MECKLENBURG COUNTY
Park and Recreation Department

MEMORANDUM

DATE: February 20, 2023

RE: Rezoning Petition #2022-175
PID# 10505103

V. OPEN SPACE

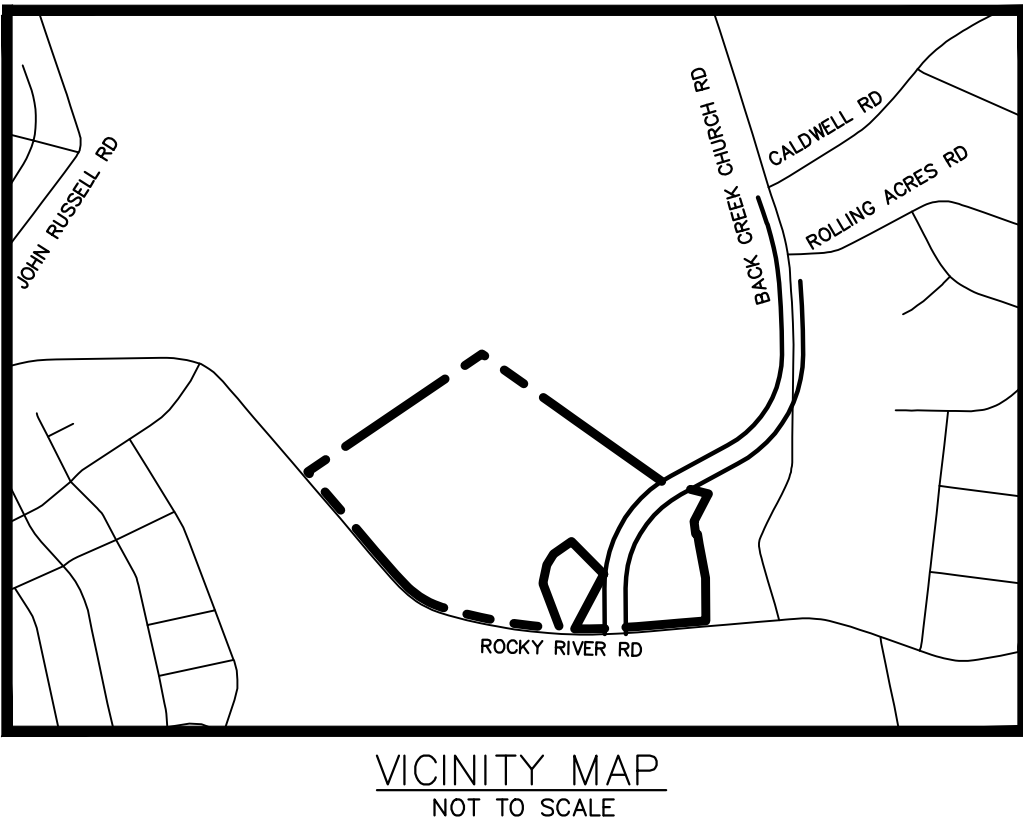
MCPR requests a minimum of **1.9** acres to be dedicated and conveyed to Mecklenburg County for a future neighborhood park. This requested park land shall be adjacent to a public right-of-way for access and is conducive for the development of the typical amenities found in a neighborhood park and cannot include tree save parcels or stormwater BMP's.
